28 April 2017

Our Reference: SYD16/00933/02 (A17256278)
DP&E Ref: SSD 7787

PROPOSED KELLYVILLE SOUTH PUBLIC SCHOOL – LOT 11 DP 247442 AND LOT 501 DP 1130020 - 21 AND 23 FAIRWAY DRIVE, KELLYVILLE

Drawing No.	Revision
AR-DA-S1 1201	P2

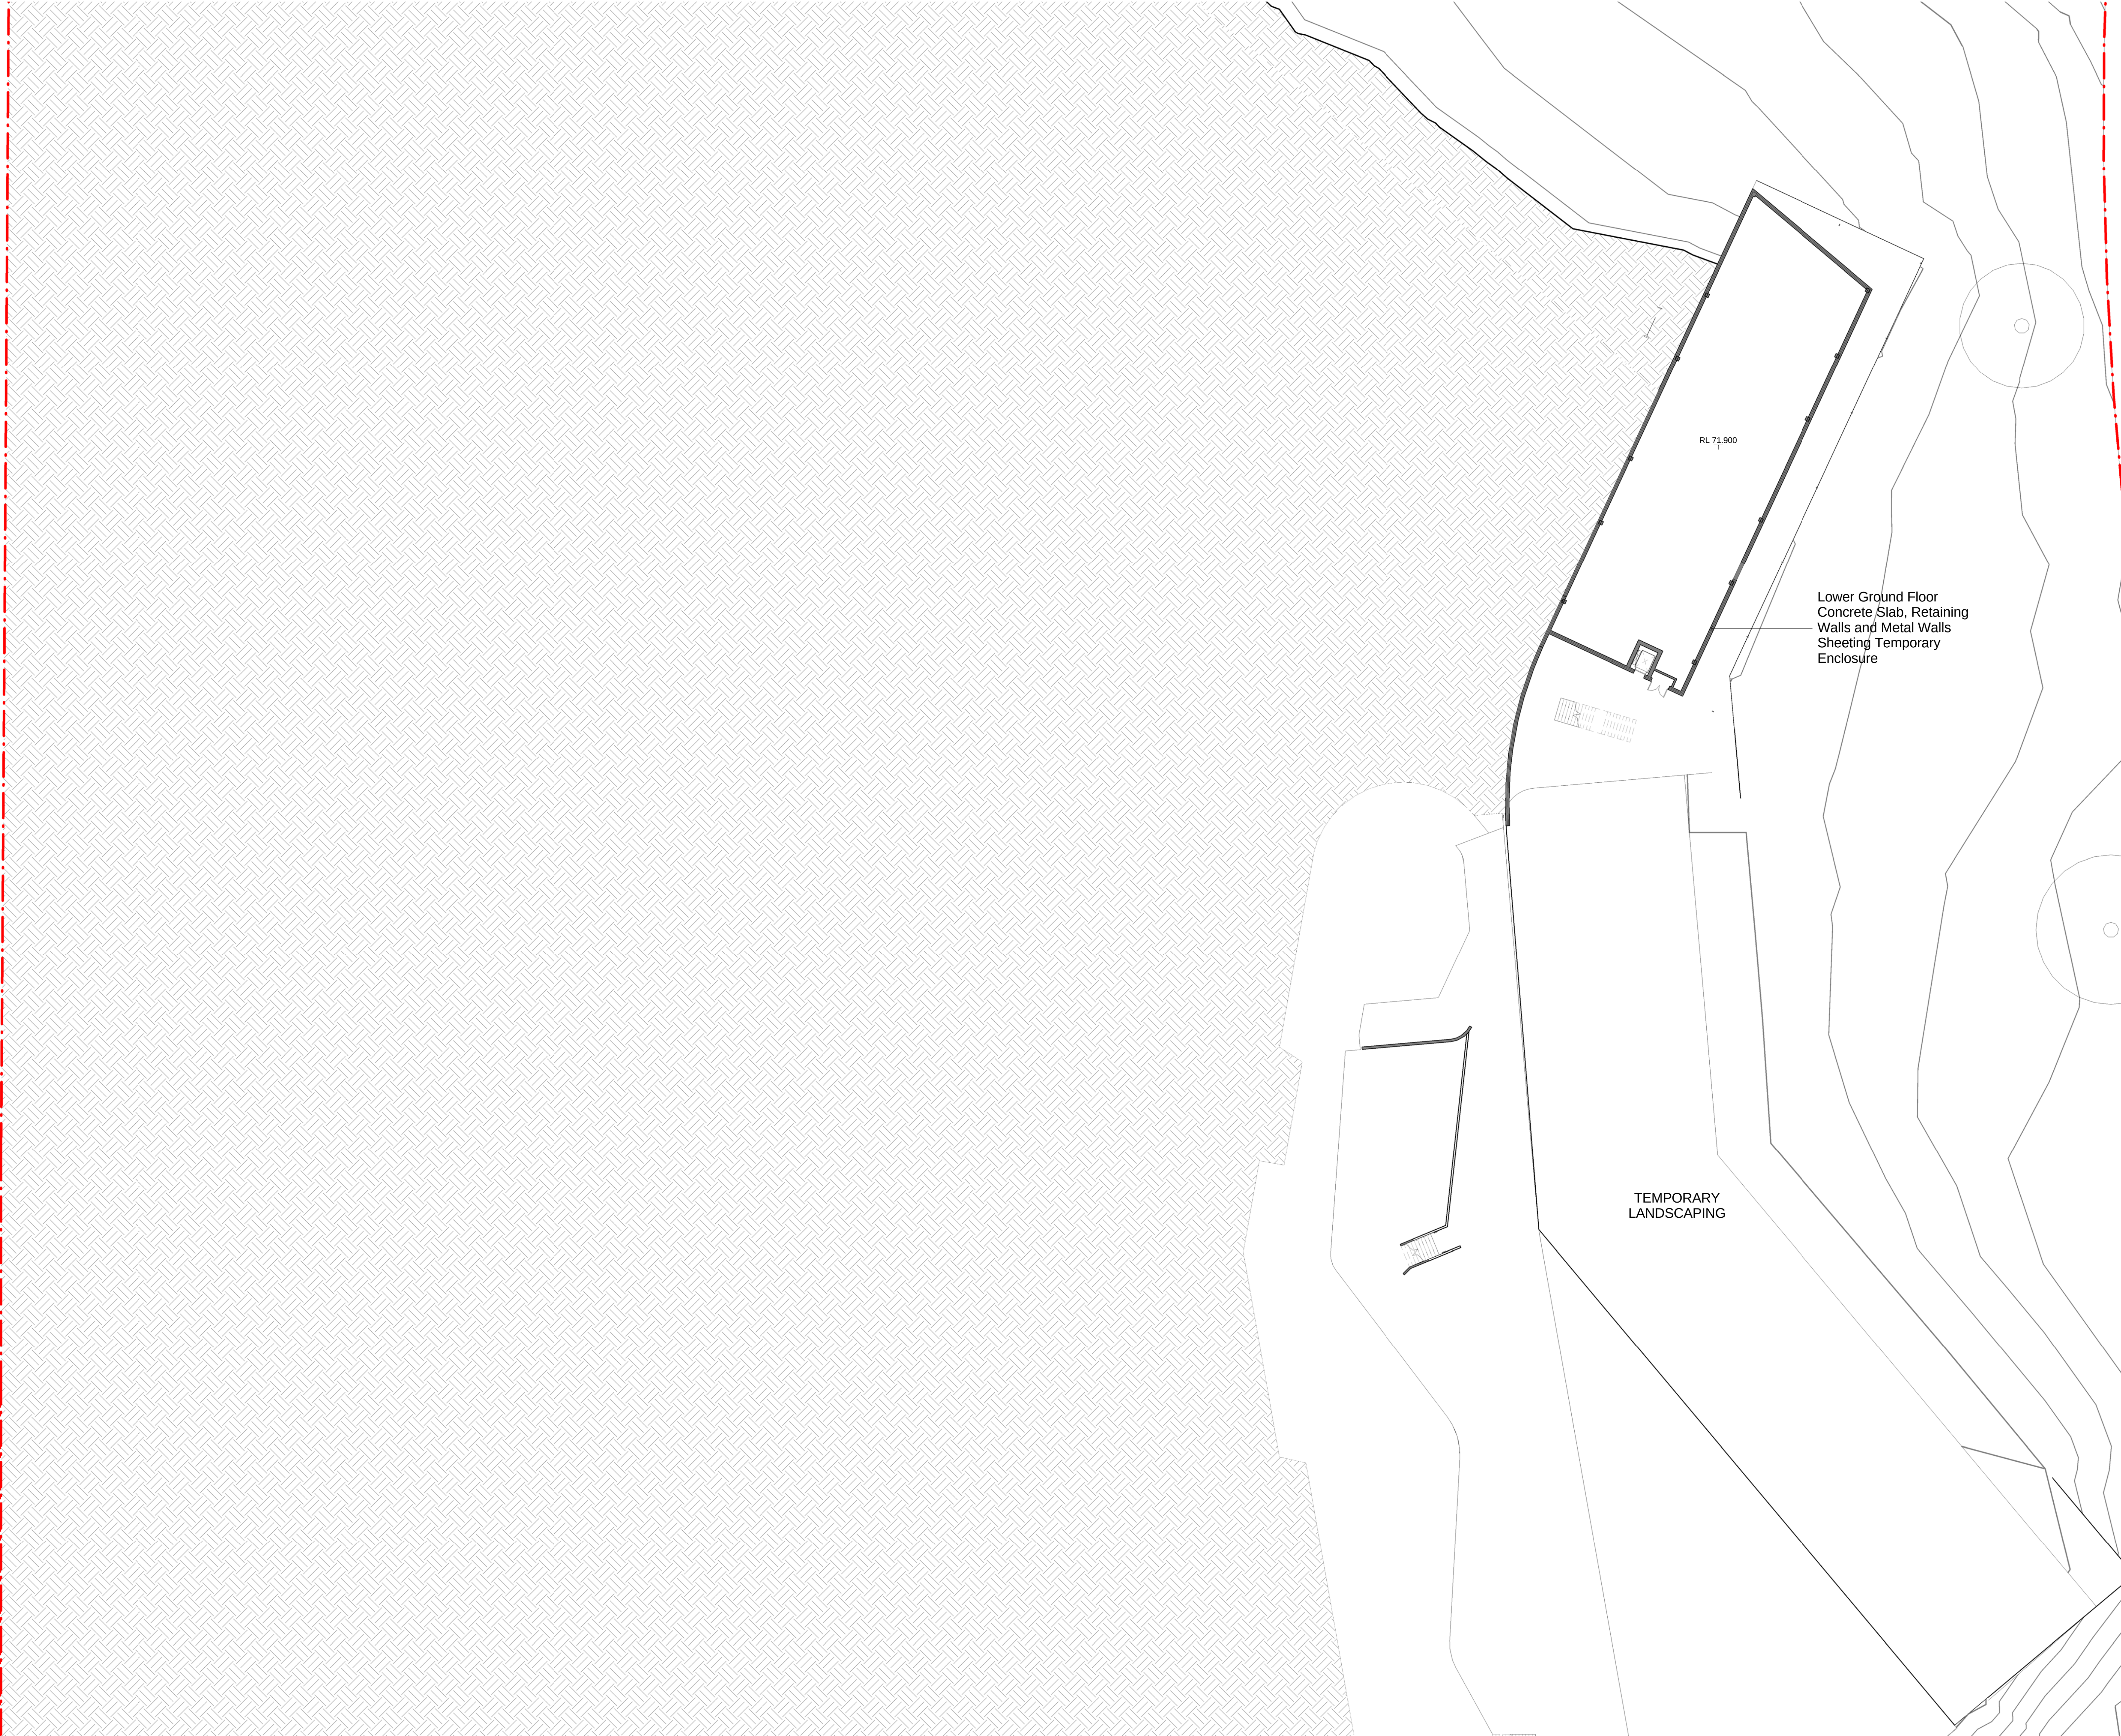
The School cannot commence before the children entry/exit gates on Free Settlers Drive, Fairway Drive and Ernesta Place are covered by a school zone.

7. Car parking shall be provided to Council's satisfaction.
8. All vehicles are to enter and leave the site in a forward direction
9. Council should be satisfied that suitable pedestrian paths/facilities are provided within the vehicle accessible areas to corral pedestrians to appropriate crossing locations.
10. Any proposed landscaping and/or fencing must not restrict sight distance to pedestrians and cyclists travelling along the footpath.
11. It is noted that there are a few proposed trees appear to be close to the Ernesta Place Carriageway. This may impact on visibility of the future school zone signage.

12. There are two bus stops located on the eastern and western side of Fairway Drive and in close proximity to the proposed zebra crossing. On this note the current roundabout design does not cater for buses that need to undertake a U-turn manoeuvre to access the bus stops. Islands adjacent to roundabout need to accommodate a refuge for pedestrians and need to comply with Roads and Maritime standards. Given that Fairway Drive is a Local road, Roads and Maritime suggests that the design of the proposed new roundabout and the proposed new crossing facilities to comply with Roads and Maritime standards and needs to be discussed with Council and follow the process as per the delegation to Council.
13. All works/regulatory signposting associated with the proposed development are to be at no cost to Roads and Maritime.
